REQUEST

Approximately 24.13 acres located on the south side of Mount Holly Road east of the intersection with Creston Circle.

The petition proposes to allow redevelopment of a site currently occupied with three single family dwellings, a triplex residential building, and two small commercial buildings with a multifamily residential community of up to ~~288~~ **268** dwelling units.

STAFF RECOMMENDATION

RZ1.00

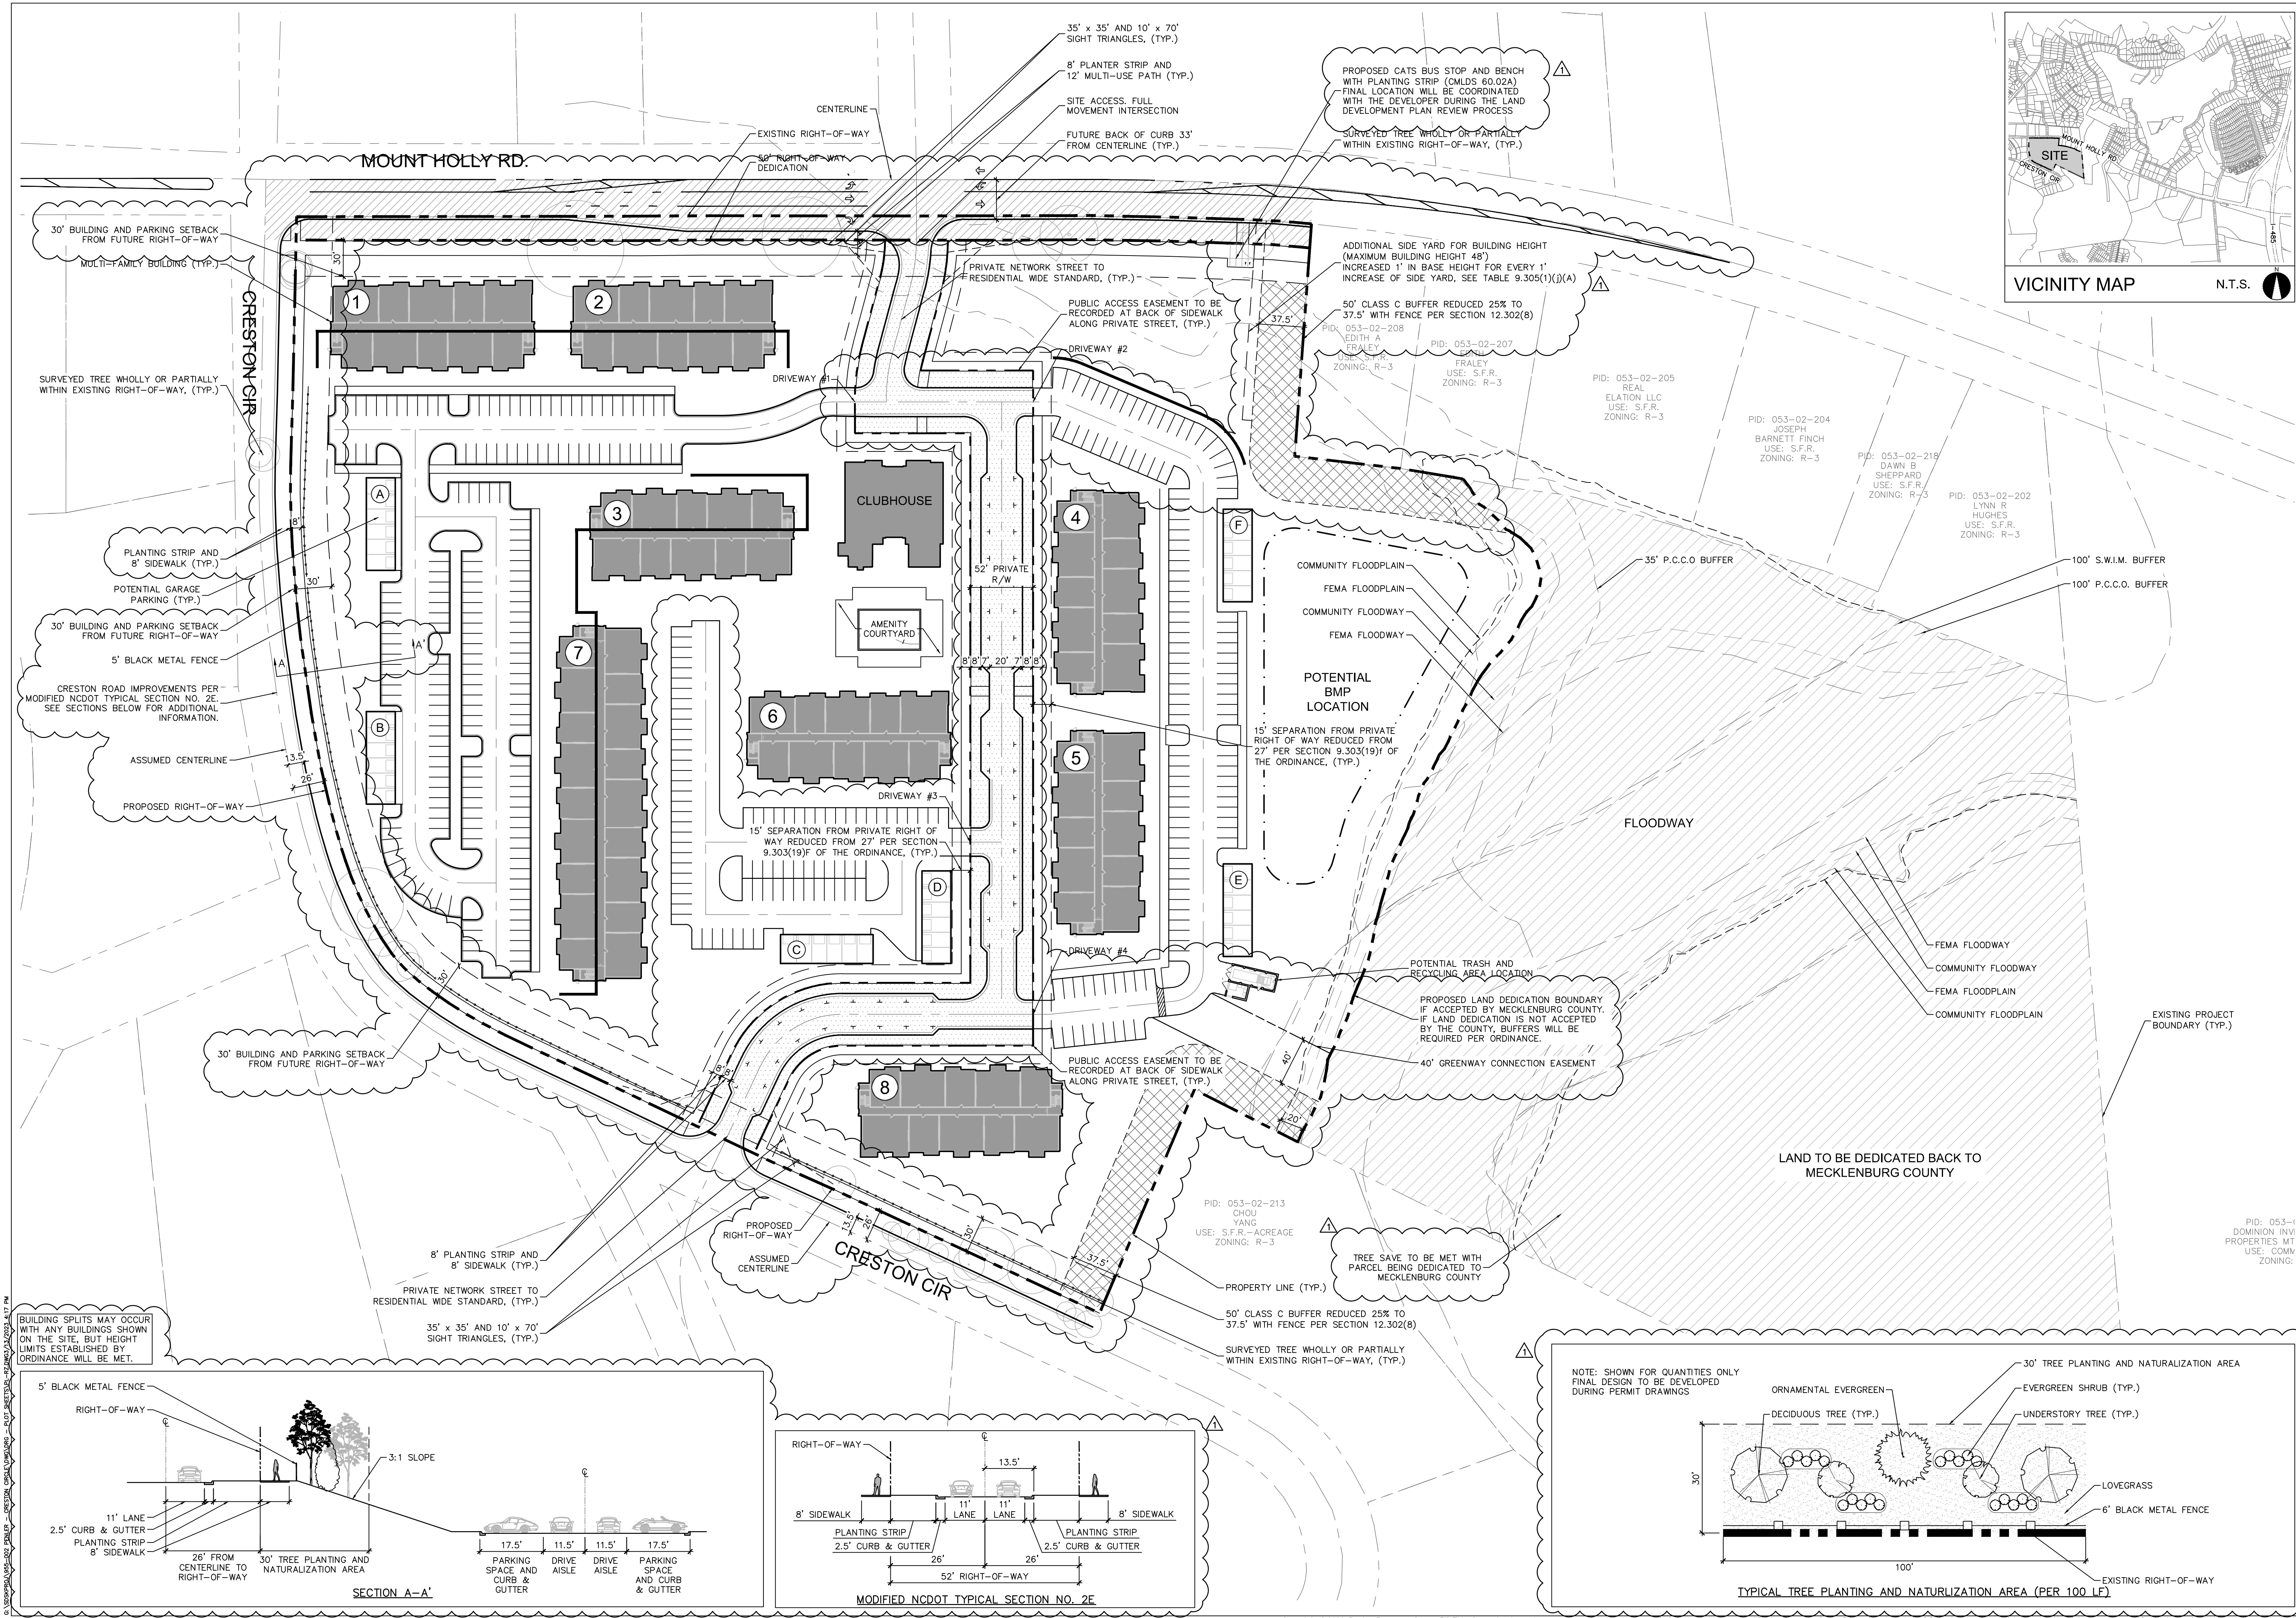
1. ~~Label and dimension the Mount Holly Road future back of curb at 33' for entire Mount Holly Road frontage. Label and dimension the Creston Circle curb and gutter to be installed at 17.5' from centerline in accordance with the Local Residential Wide typical section (CLDSM U-03).~~ **ADDRESSED**

2. ~~Revise site plan and conditional notes to commit to upgrading Creston Circle to the proposed site access in accordance with the Local Residential Wide cross section (CLDSM U-03).~~ **ADDRESSED**

3. ~~Remove or modify the proposed phasing for the development (Note J). Creston Road improvements need to be completed prior to first CO for the site, or a more balanced phasing plan needs to be proposed. The current proposed phasing based on CO for building 8 leaves too much public infrastructure work outstanding for the last building based on the overall project scope, and it is not proportional. Updated comment: Update proposed note to include buildings 4-8. Creston Road improvements need to be completed prior to first CO for the site, or a more balanced phasing plan needs to be proposed. The current proposed phasing based on CO for building 4 leaves too much public infrastructure work outstanding for the last building if buildings are not constructed in sequence, and it is not proportional. In addition, Creston Circle improvements should be completed prior to access to Creston Circle is permitted.~~ **ADDRESSED**

4. ~~Extend the proposed greenway access easement to the public street right-of-way so that Mecklenburg County can access the dedicated parcel area.~~ **ADDRESSED**
5. ~~Provide a tree survey identifying all trees of 8" DBH or greater and all planted trees of 2" caliper or greater and 6' in height that grow partially or wholly within the city right-of-way.~~ **ADDRESSED**
6. ~~Label tree save on the site. The tree save area must be outside of the area to be dedicated to Mecklenburg County.~~ **ADDRESSED**
7. ~~Ensure that all parking spaces and garages are outside of the setback.~~ **ADDRESSED**
8. ~~Ensure that the buildings meet the 27' or 30' setback due to lack of entries on the street elevation.~~ **ADDRESSED**

9. ~~Revise site plan and conditional notes to a building type that better aligns with the Neighborhood 1 Place Type.~~ **OUTSTANDING**
